**Our ref:** RA/2015/132060/03-L03  
**Your ref:** EN060004  
**Our ID:** 10031562  
**Date:** 12 October 2015

### ANSWERS TO FIRST WRITTEN QUESTIONS

**A REPLACEMENT HIGH-PRESSURE GAS PIPELINE WITHIN A BORED TUNNEL BENEATH THE HUMBER ESTUARY AND ASSOCIATED DEVELOPMENT, INCLUDING A CONNECTING PIPELINE, MINOR MODIFICATIONS TO PAULL ABOVE GROUND INSTALLATION AND ASSOCIATED TEMPORARY LAY DOWN, WORKING AND MITIGATION AREAS. FROM PAULL, EAST RIDING OF YORKSHIRE TO GOXHILL, NORTH LINCOLNSHIRE.**

RIVER HUMBER GAS PIPELINE REPLACEMENT PROJECT		
INDICATIVE PAULL SITE LAYOUT FIGURE 2.4 B		
REFERENCE		
DRAWN	CHECKED	APPROVED
JN	KB	NH
SCALE	ORIG SIZE	SHEET
1 : 1000	A1	1 of 1
DATE		REVISION
12 OCT 15		03

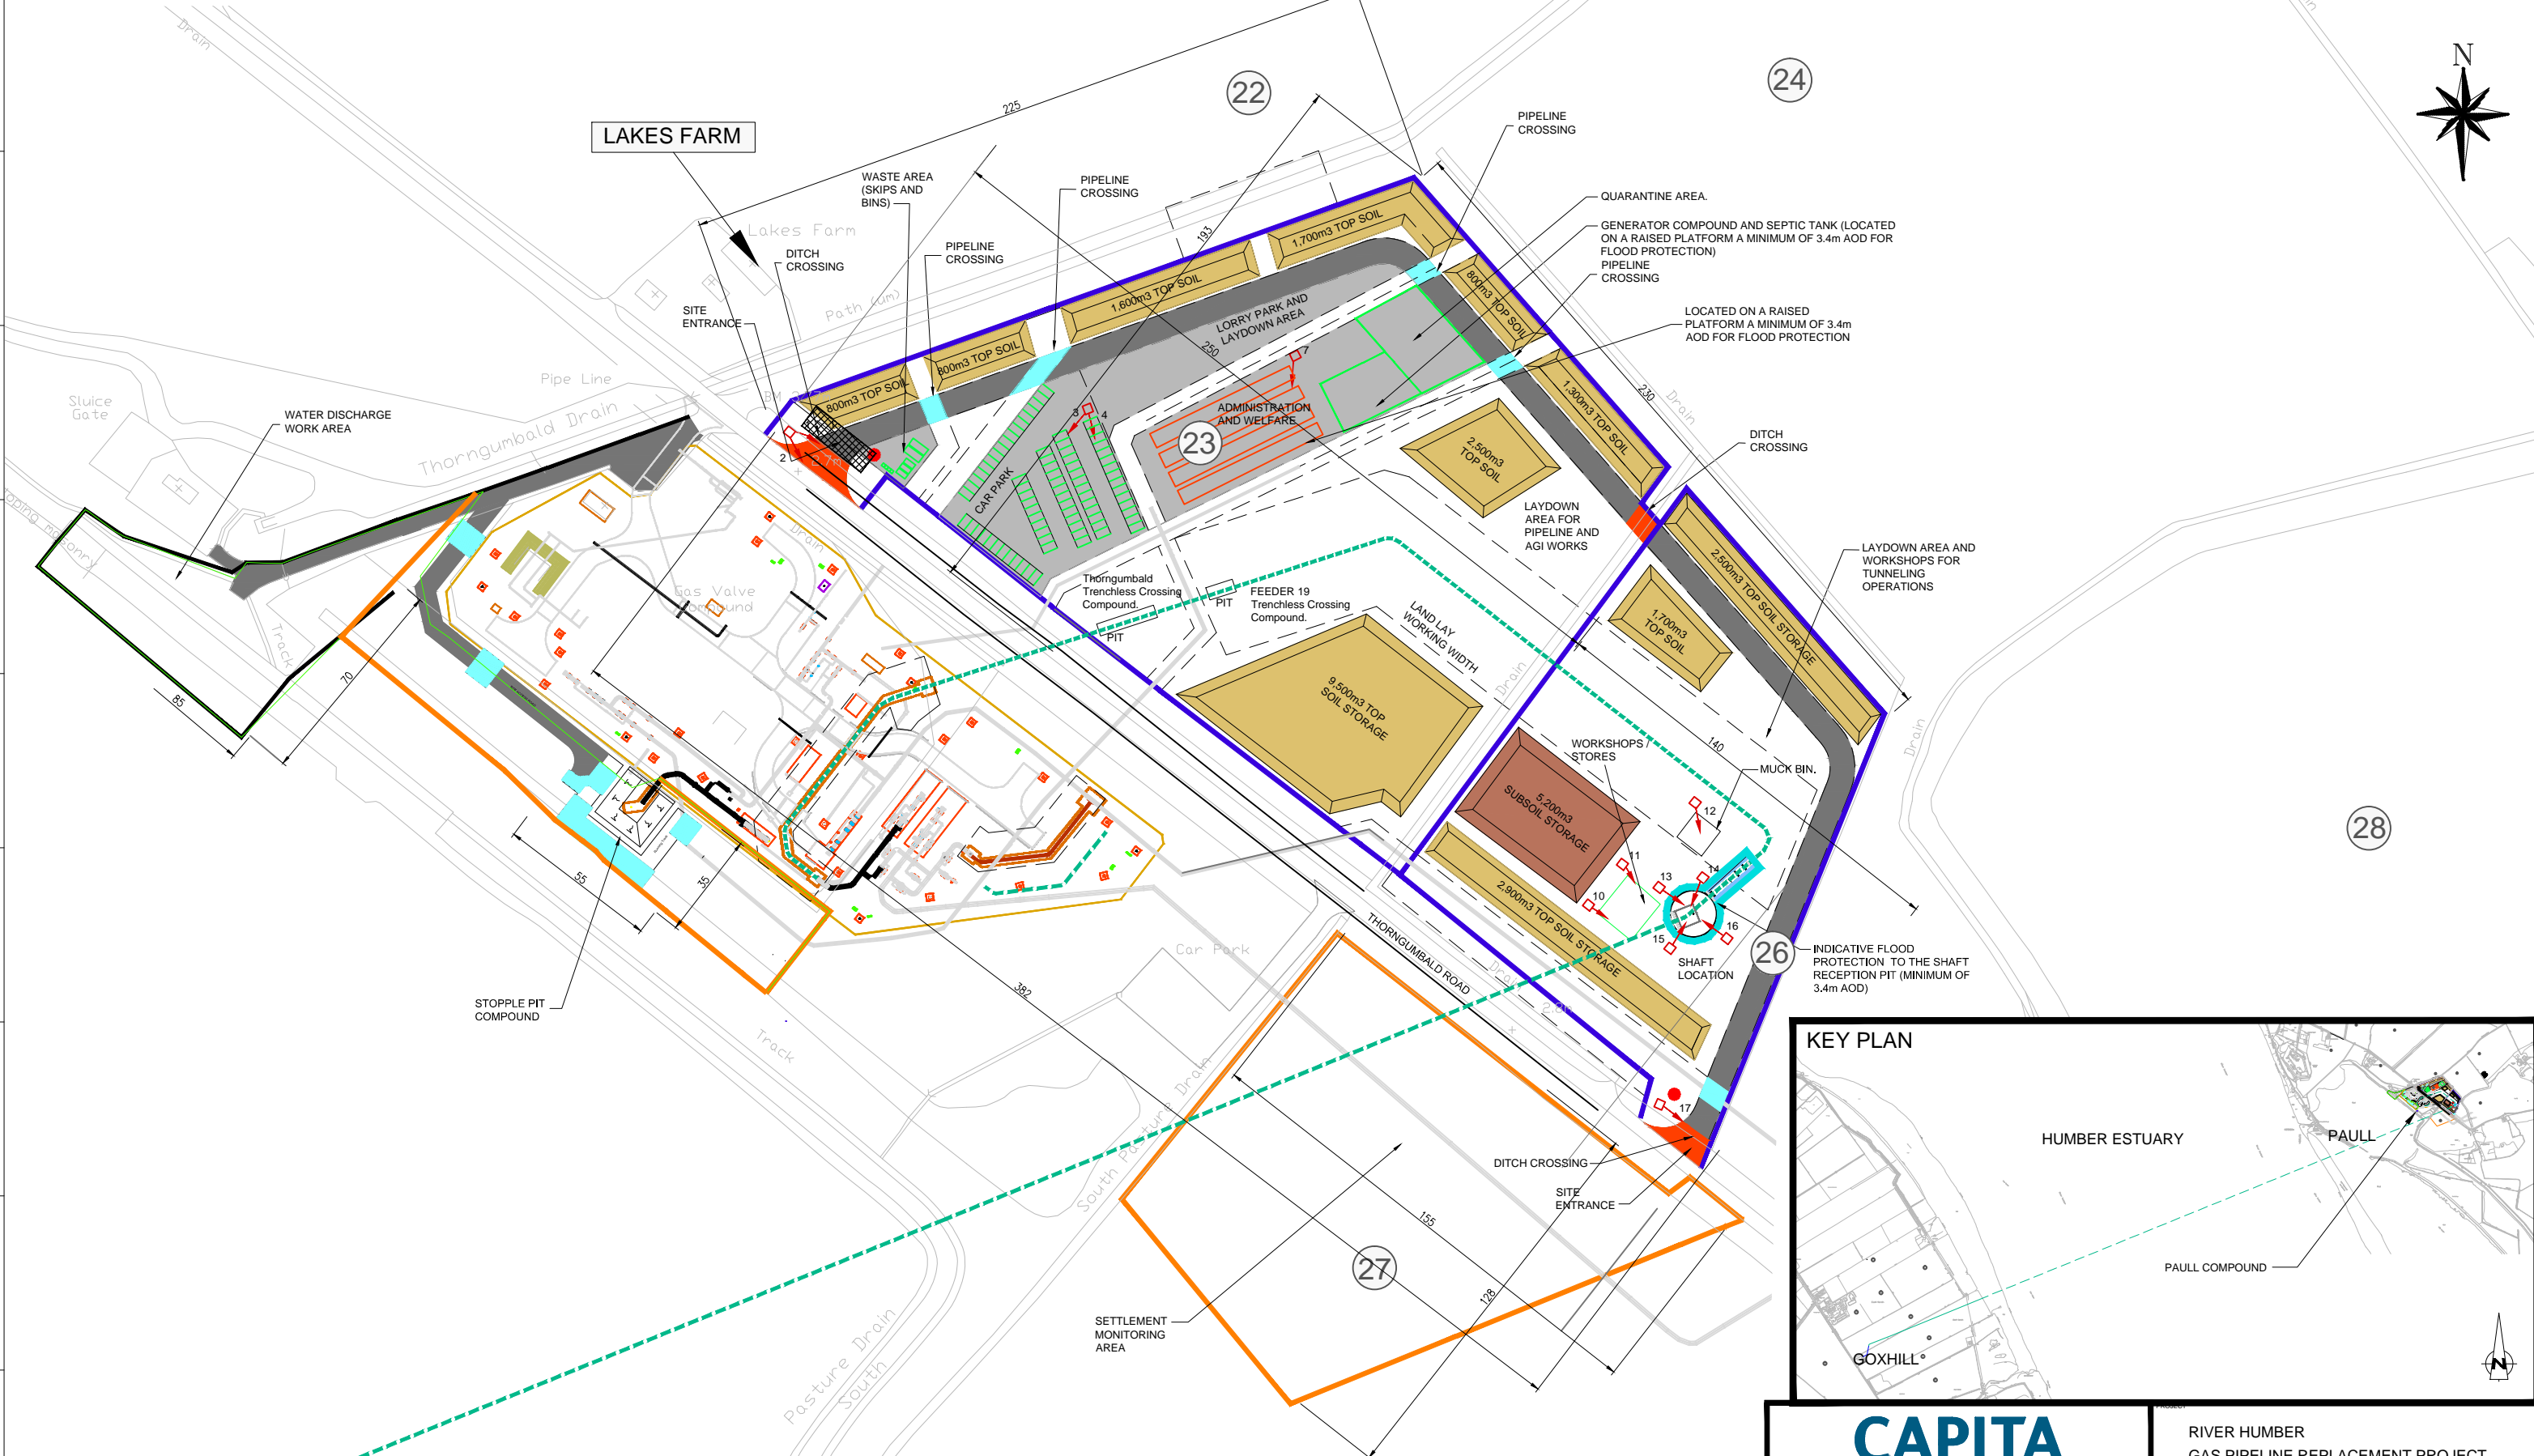
<b>Question 4.2</b>	<b>Applicant</b>	Have water discharge points at Goxhill and Paull been agreed with the EA, the North East Lindsay Drainage Board (NELDB) and the South Holderness Internal Drainage Board (SHIDB)? Note [RR-010] from the EA which at 2.1(8) states ' <i>The 'Indicative Paull Site Layout' shows an area denoted as the 'water discharge work area' which appears to coincide with the existing flood defence and Thorngumbald Pumping Station outfall. More detail is requested to assess any potential impacts'</i>
<b>Answer to 4.2</b>		This is of interest to the EA as a landowner, as we have not yet received any details of proposals for the water discharge area at Paull following our site meeting with the applicant/agent.
<b>Question 4.8</b>	<b>Environment Agency; North East Lindsay Drainage Board &amp; South Holderness Internal Drainage Board</b>	Schedule 3 – Requirement 9, Agricultural Land Drainage – is sufficient information known about the project from the application documentation to secure and maintain adequate drainage provision throughout? Are the Environment Agency able to verify that that there is no major concern (related to agricultural land drainage) to the possible grant of an order? If there are outstanding concerns please identify them and what you would require to reduce or remove them?
